Final Report - Corrections Required **Application No. LUPL-25-0008**

Report Date: 12/12/2025

Document Filename : 241010_BLR Village C Land Use Plan.pdf

ISSUE RECORD

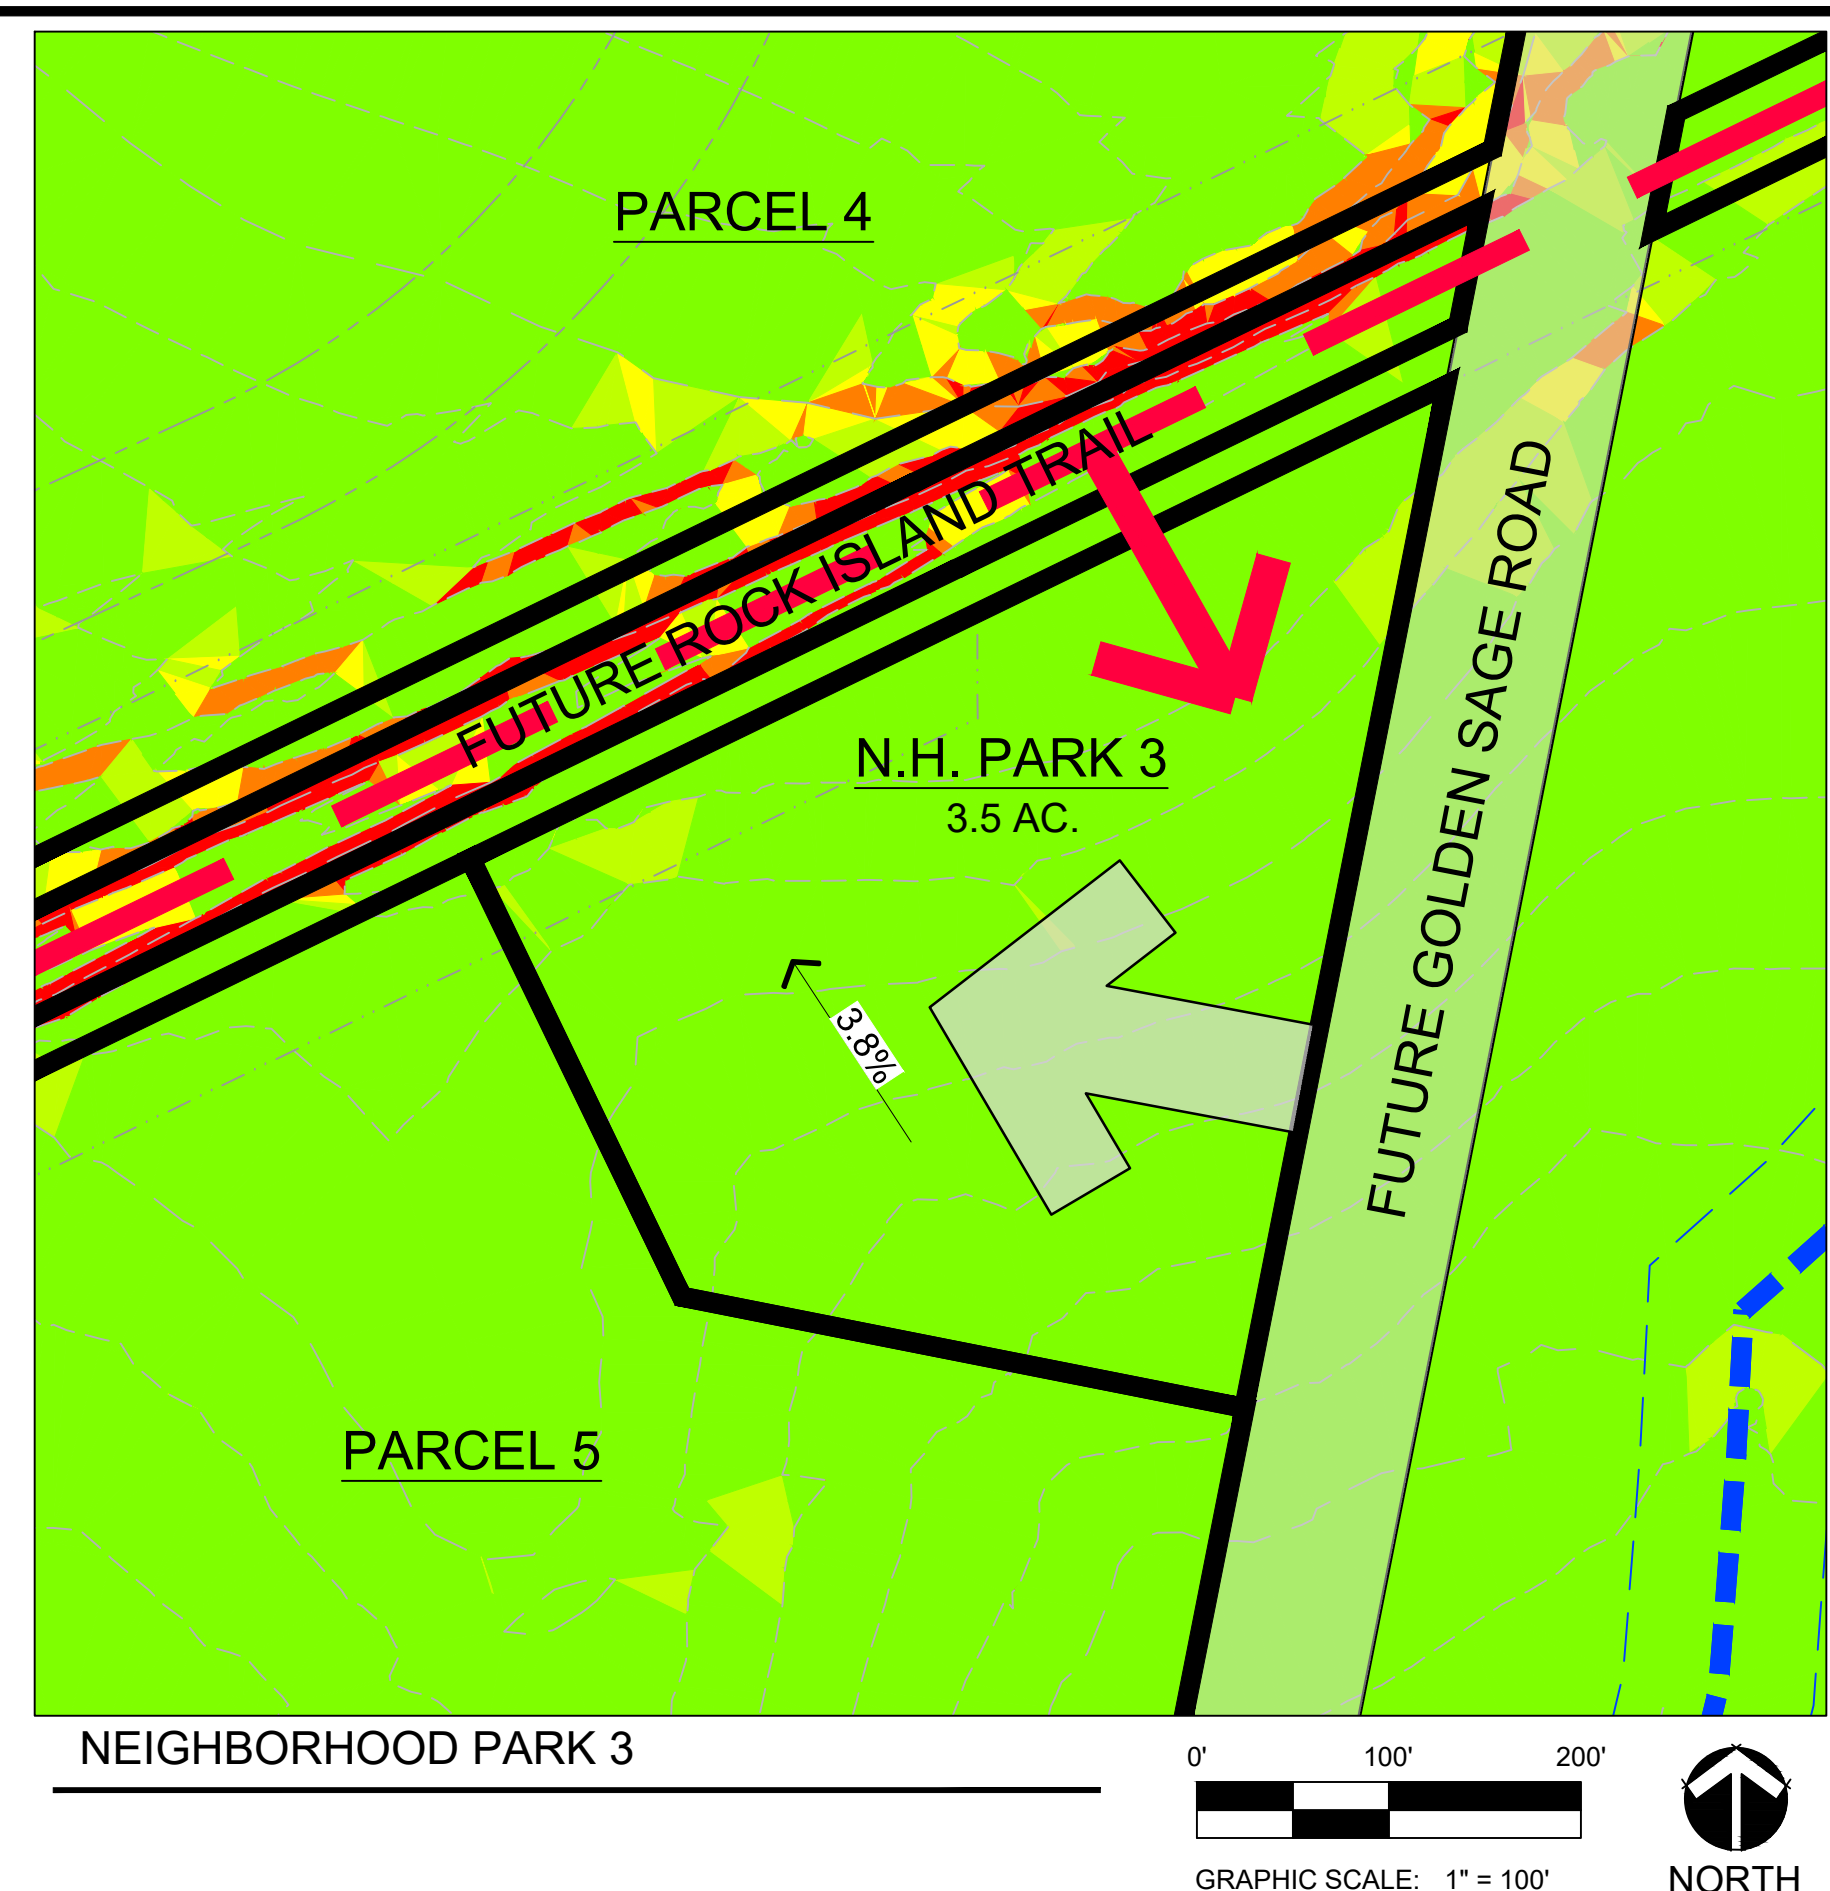
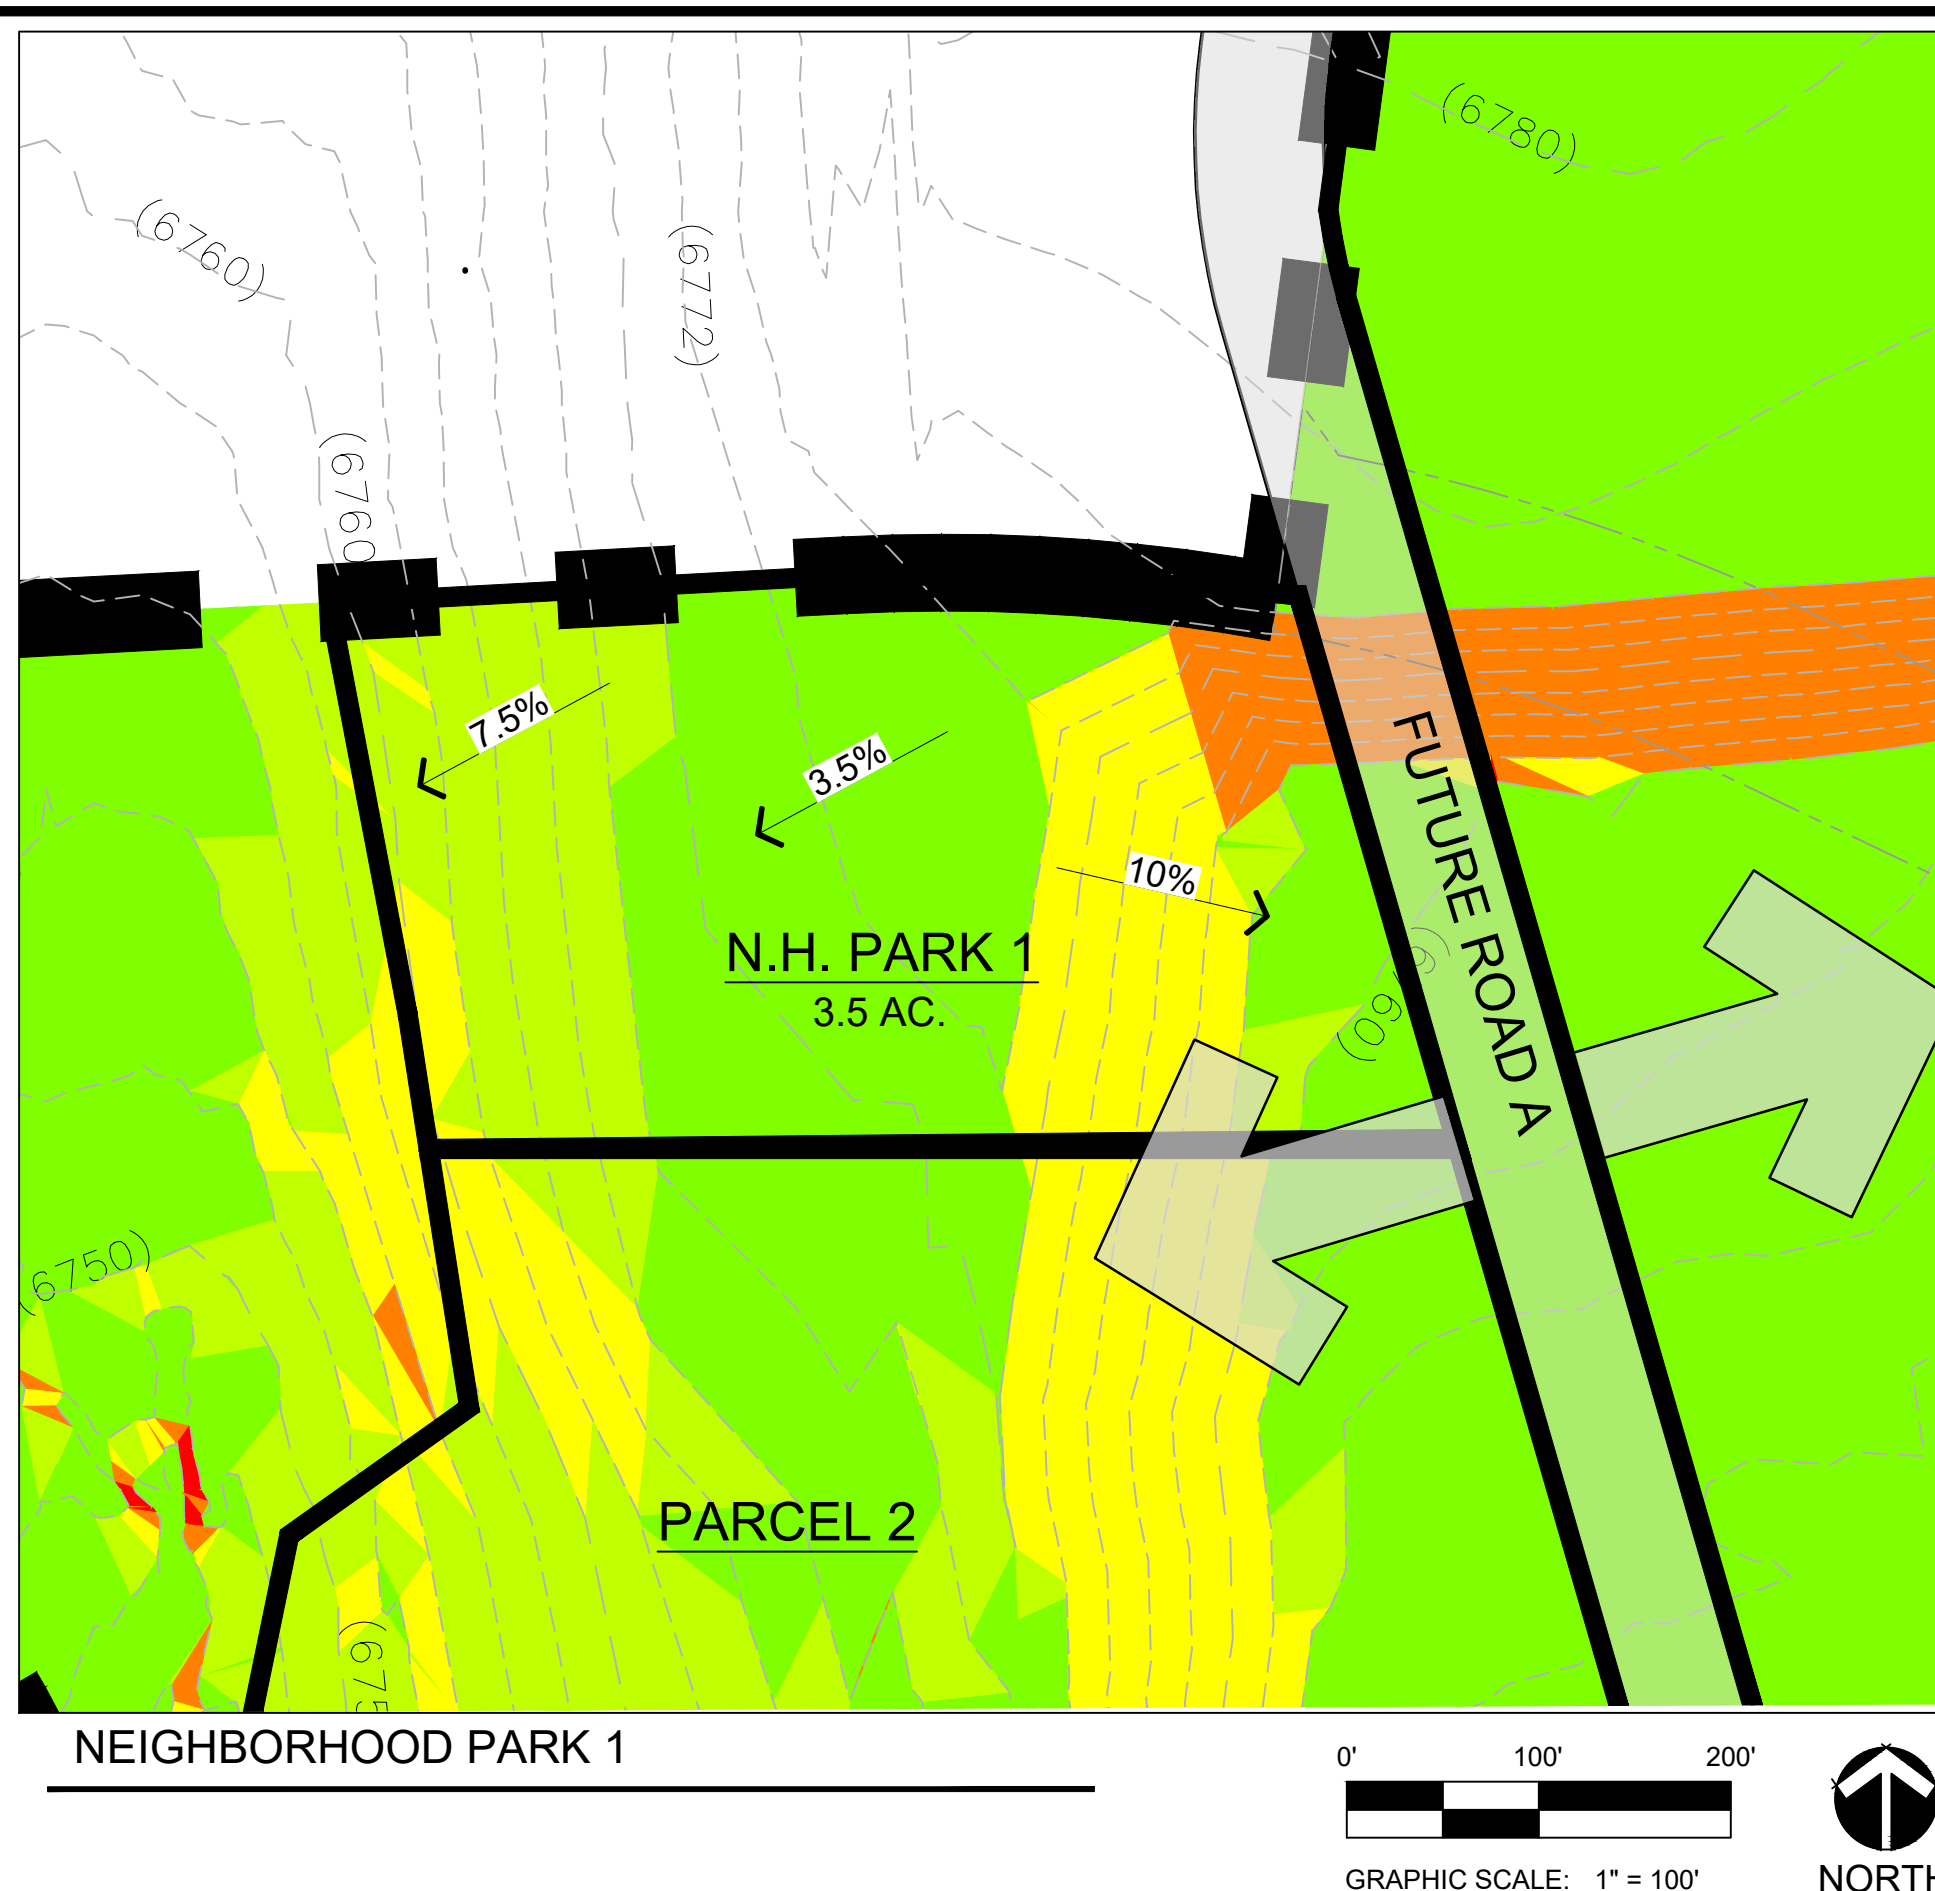
Comment ID	Page Reference	Reviewer : Department	Review Comments
15	1	Caroline Miller : Planning	<p>PLDO Reviewer would like for Village B2 and C to go to Parks Advisory Board prior to City Planning Commission to highlight PLDO obligations through the Master Plan/Land Use Plan and how they are to be met through the spread of Neighborhood Parks and summed Village C Community Park site. This will take two months, the first month as a presentation item, the second month as an action item, once Parks comments are resolved on Village C.</p> <p>In addition, Parks is awaiting feedback regarding the developer building the Community Park, then dedicating it to the city. A Community Park amenity list was provided in April to help the conceptual feasibility discussions. Notes will likely be added to this LUP in the future, upon developer response.</p>
25	2	District #49 : School Districts	PK-8 proposed
